File No: NTH18/00058

Your Ref: SSD 9255

New England Highway [HW9]: New England Solar Farm (SSD 9255) EIS Exhibition Uralla.

I refer to your email of 19 February 2019 requesting comment from Roads and Maritime Services in relation to the abovementioned development proposal.

APPENDIX 4

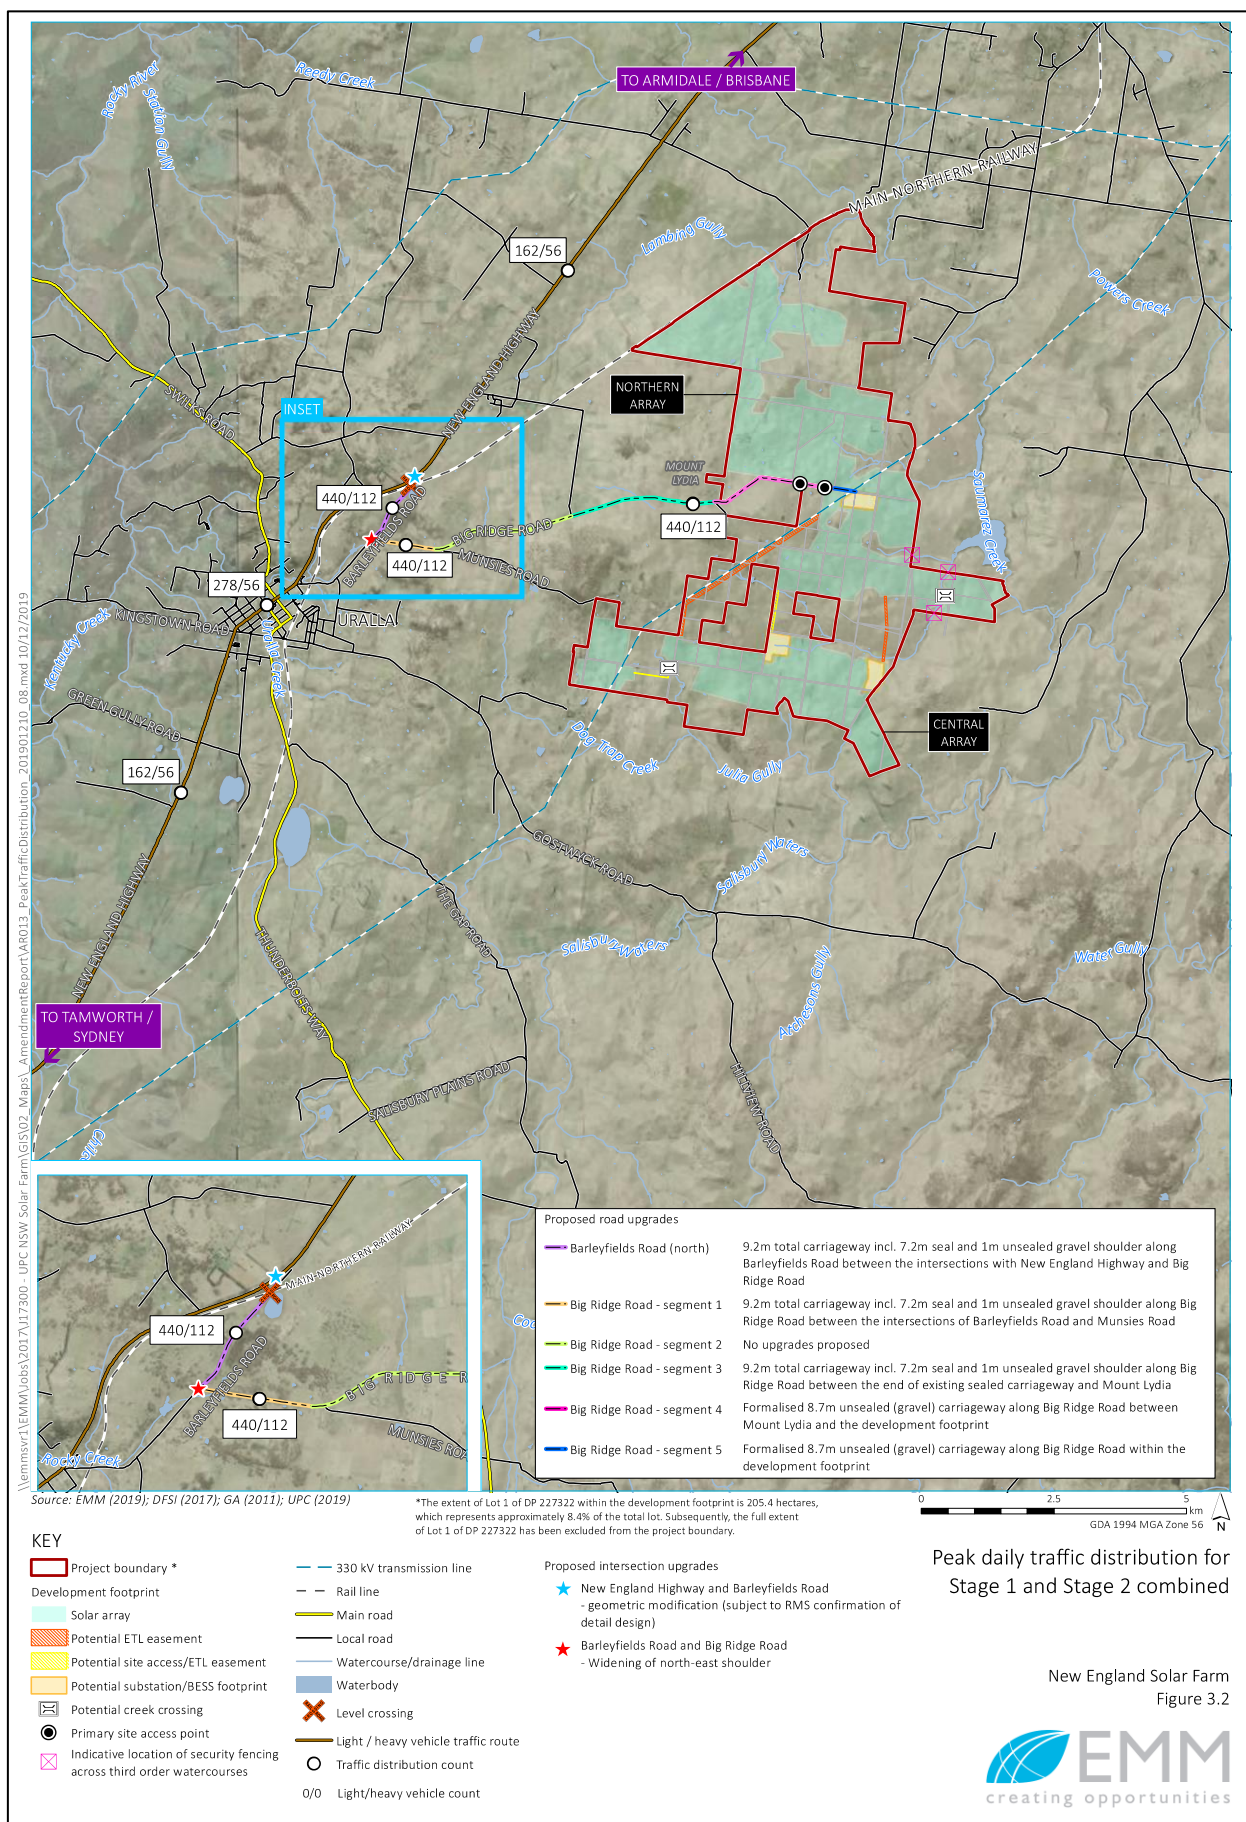
- The Traffic Impact Assessment (TIA) did not provide sufficient details quantifying the proposed traffic management arrangements. Detail such as concepts designs for the recommended intersection improvements which should include an assessment of sight distances, swept paths and access treatment arrangements.

- Roads and Maritime is planning to undertake changes to the intersection of the New England Highway and North Barleyfields Road. It is recommended the New England Solar Farms proposed road works on the highway should be co-ordinated with Roads and Maritime to achieve safe and efficient outcome.

All works on the classified roads will need to be designed and constructed in accordance with the current Austroads Guidelines, Australian Standards and Roads and Maritime Supplements.
